MEMORANDUM

TO: Jean Fraser, Planner
FROM: David Senus, P.E. & Ashley Auger, E.I.T.
DATE: January 16, 2014
RE: 118 on Munjoy Hill, Level III Site Plan Review

Woodard & Curran has reviewed the revised Level III Site Plan Application for the development project located at 118 Congress Street in Portland, Maine. The project will involve the construction of a new four story mixed-use building consisting of residential units and retail space.

EROSION CONTROL PLAN

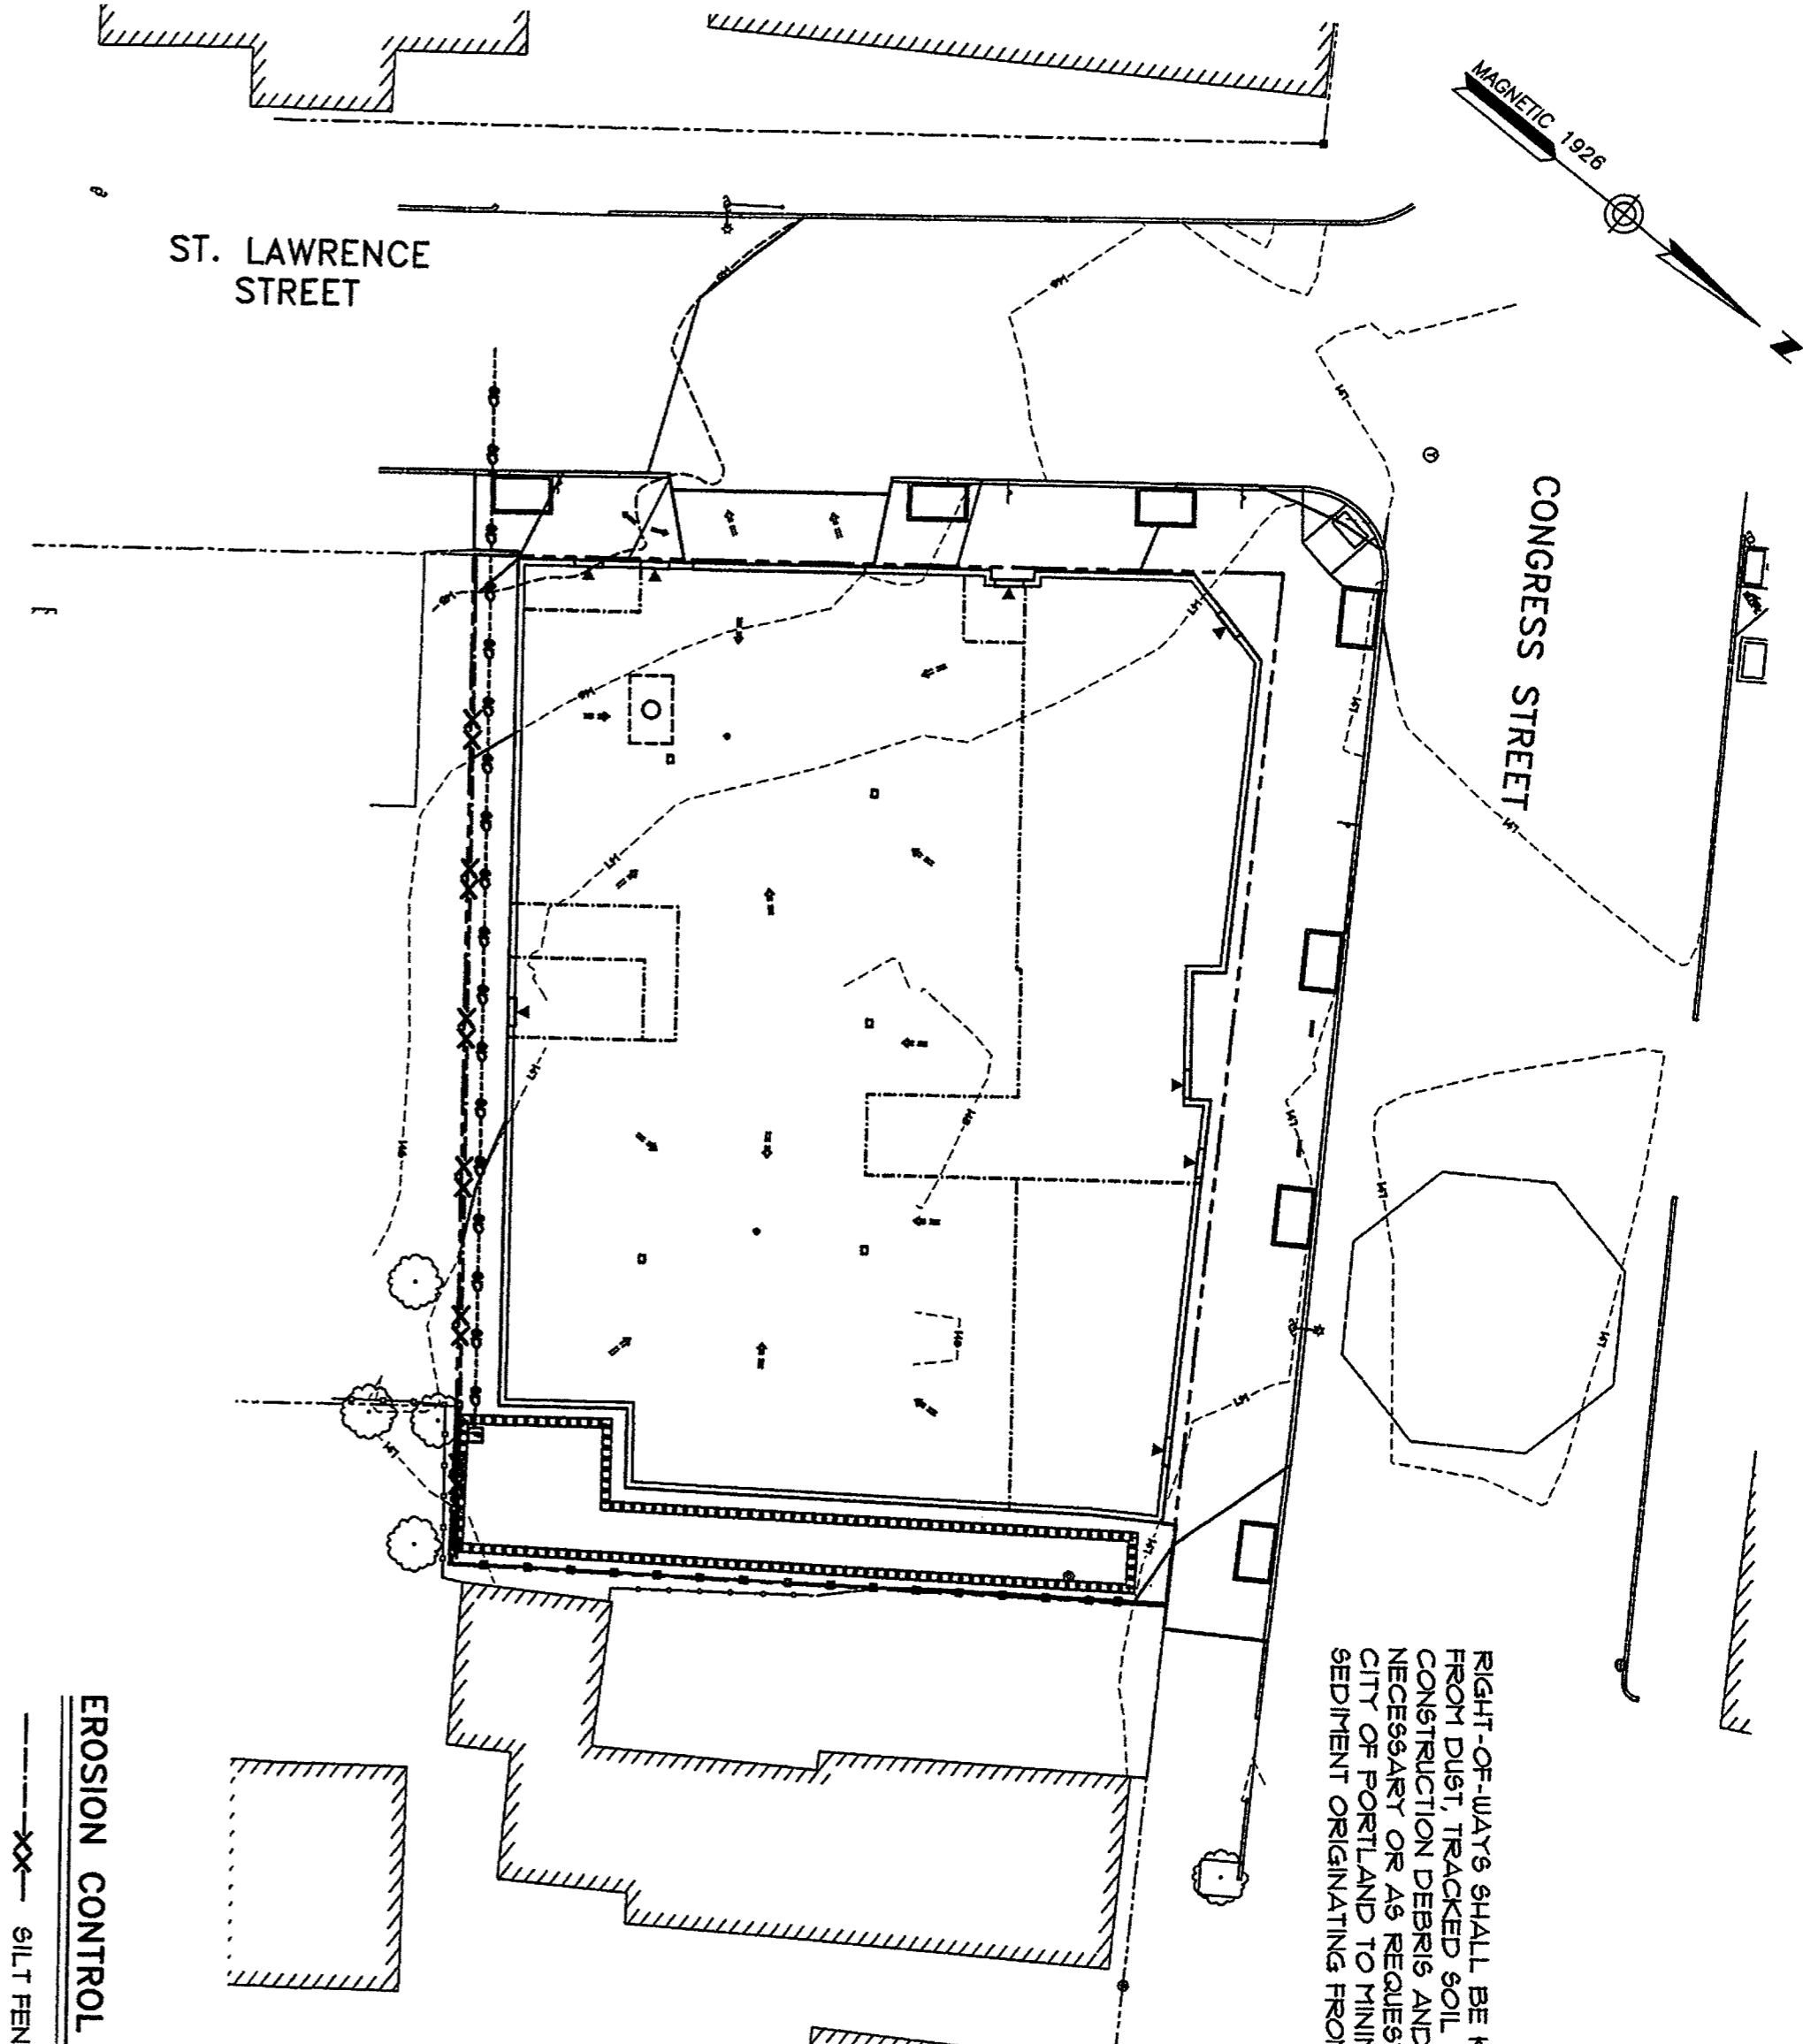
- 2) The Applicant has provided a plan, notes, and details to address erosion and sediment control requirements, inspection and maintenance requirements, and good housekeeping practices in general accordance with Appendix A, B, & C of MaineDEP Chapter 500. The plan should also include a note stating that the street Right-of-Way shall be kept clean from dust, tracked soil/mud, and construction debris and swept as necessary or as requested by the City of Portland to minimize dust and sediment originating from the site.

6 PAVEMENT CUTTING & MATCHING SECTION  
NOT TO SCALE

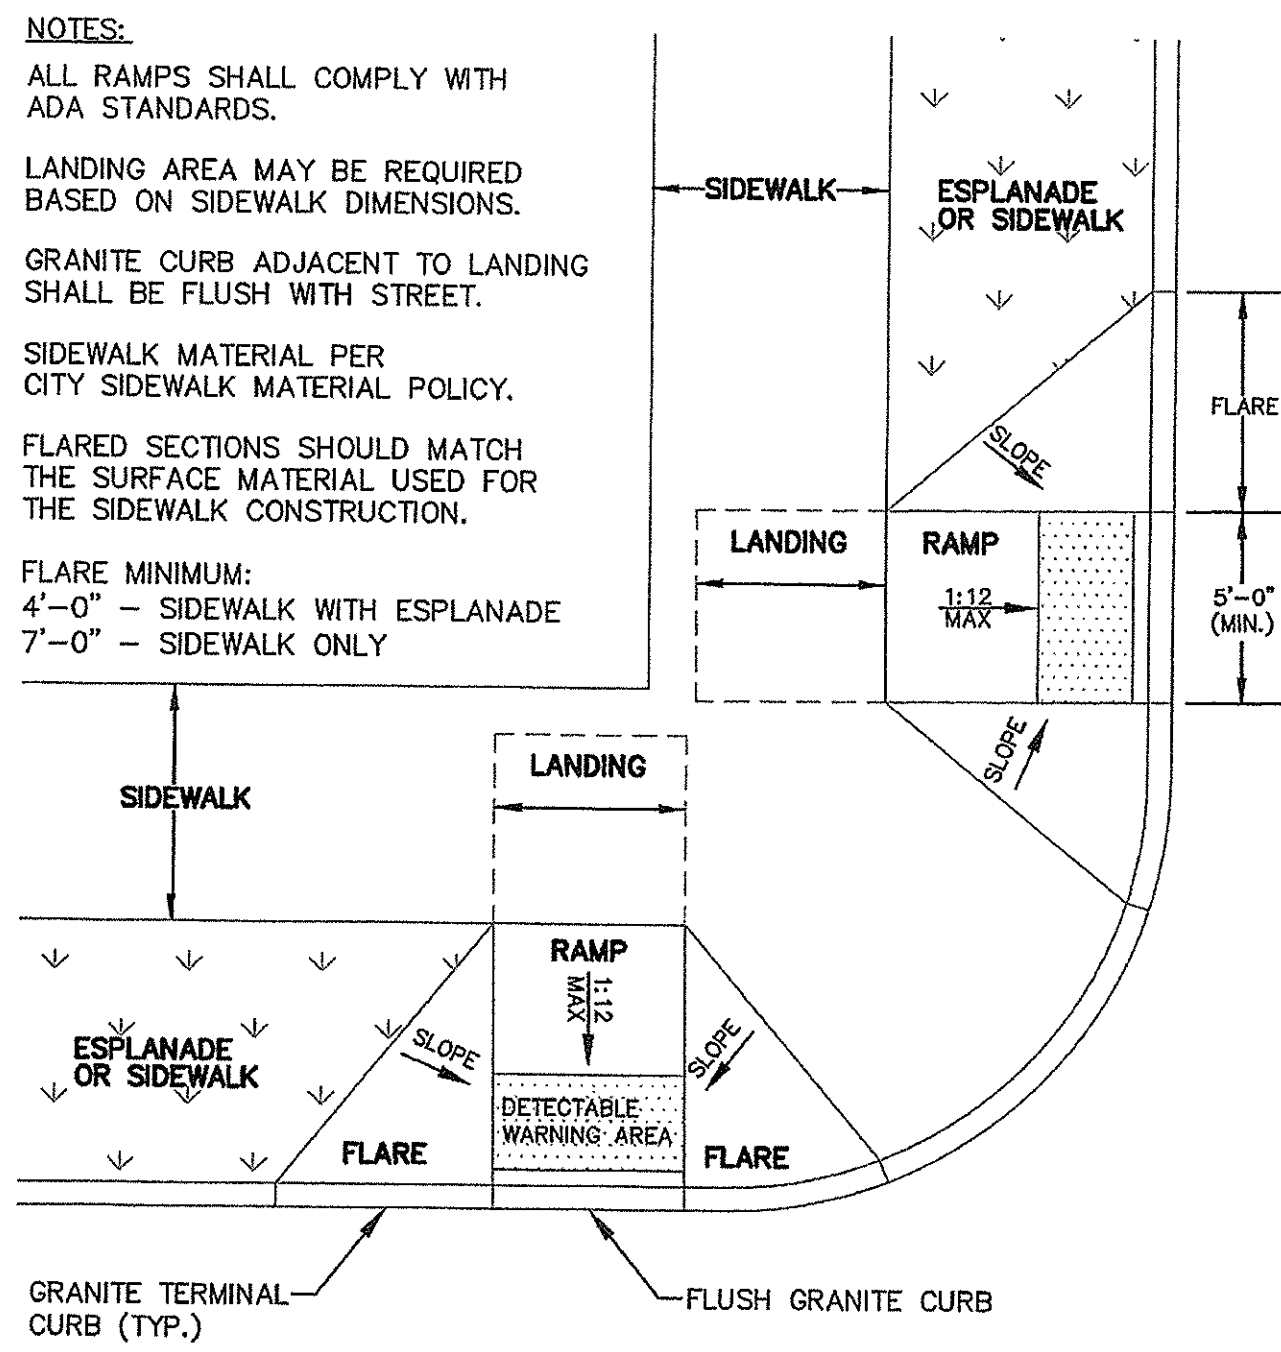
- 5) The following details for work within the City Right-of-Way should be provided in accordance with the City's Technical Manual:
 - a) Pavement Repair Cross Section detail

1 CITY OF PORTLAND BRICK SIDEWALK/CURB DETAIL
L2.0 NOT TO SCALE

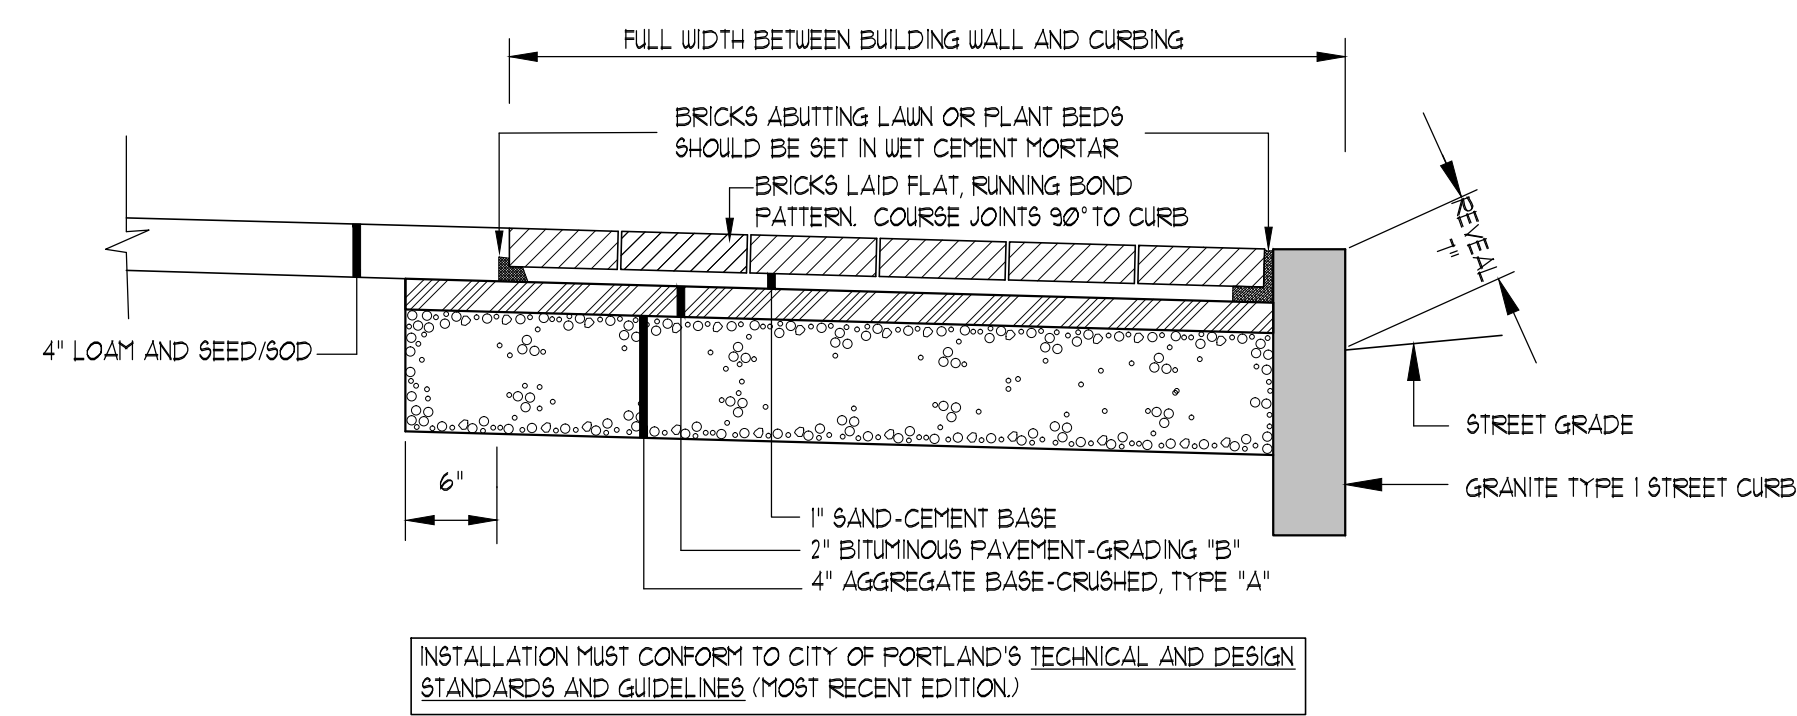
- b) Brick Sidewalk detail
- 6) All previous review comments have been adequately addressed.
